<Tim.Bamford@kirklees.gov.uk>**Subject:** Objection Application No. 2024/62/90275/E Development at 11 Station Road, Skelmanthorpe**Importance:** High

I have been asked to write to you on behalf of Upper Dearne Valley Environmental Trust (UDVET) with a strong objection against the above proposal on the following grounds:-

Residential Development  
 @ 11 Station Road, Skelmanthorpe, Huddersfield, West Yorkshire HD8 9AU  
 Proposed new house 11 A Station Road  
 Cellar, First , Attic & Roof Plans - Drawing no. Pmrca QH11A-02 Revision A  
 Scale 1:100

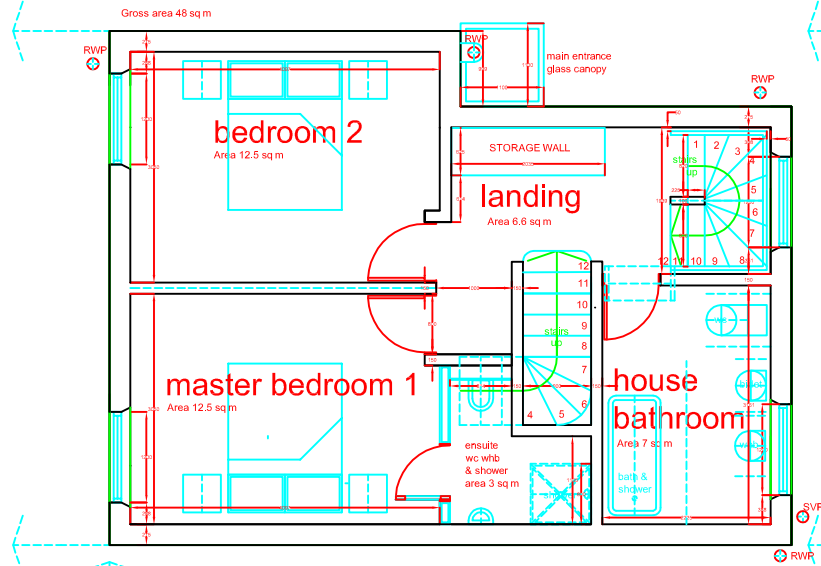
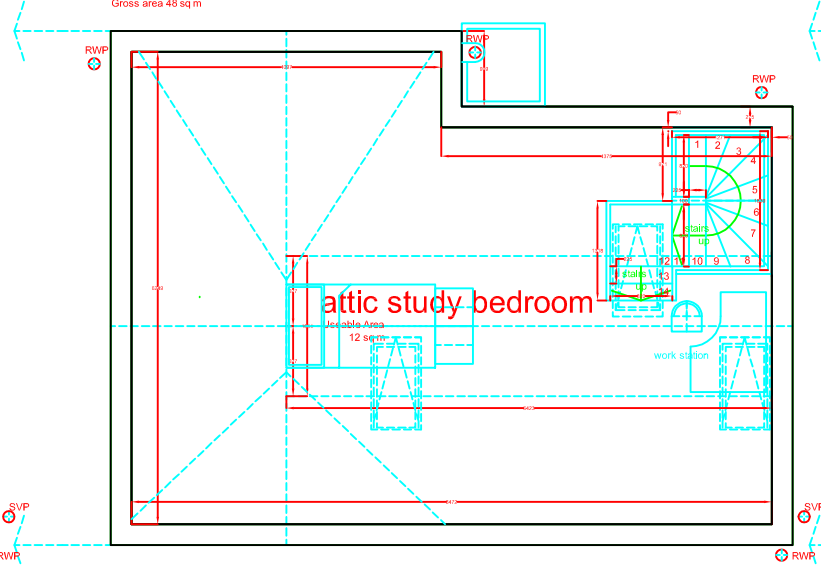
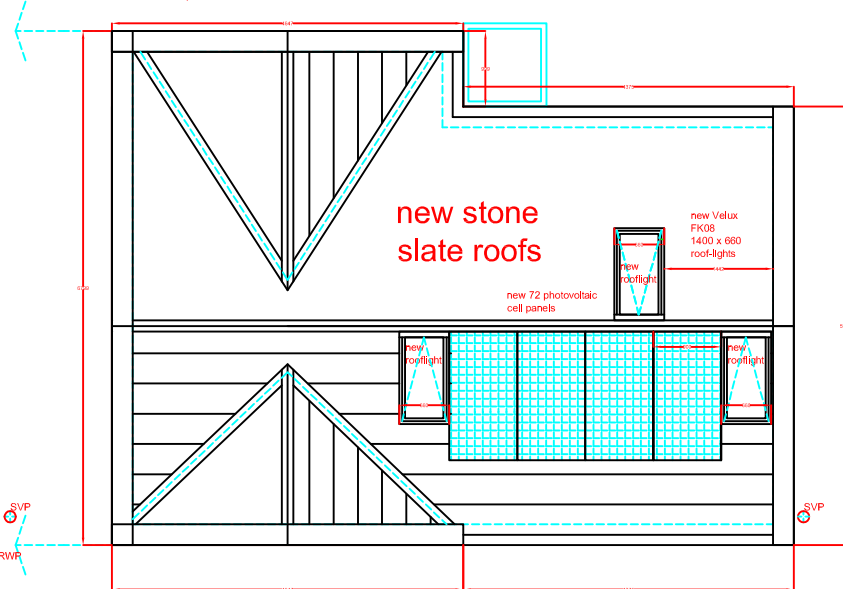
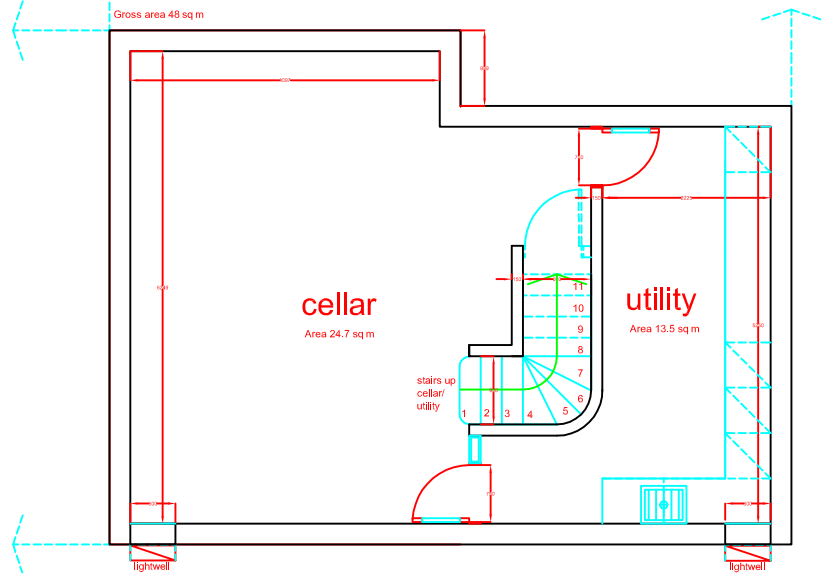
- The western boundary of the property ends in a steep banking sloping down into Holly Tree Grange. There is a garage at its base and part of this banking is supported by gabions. To construct a house with a basement risks creating instability.
- There is no room to manoeuvre and park three vehicles on this small piece of land if the proposed property is built.
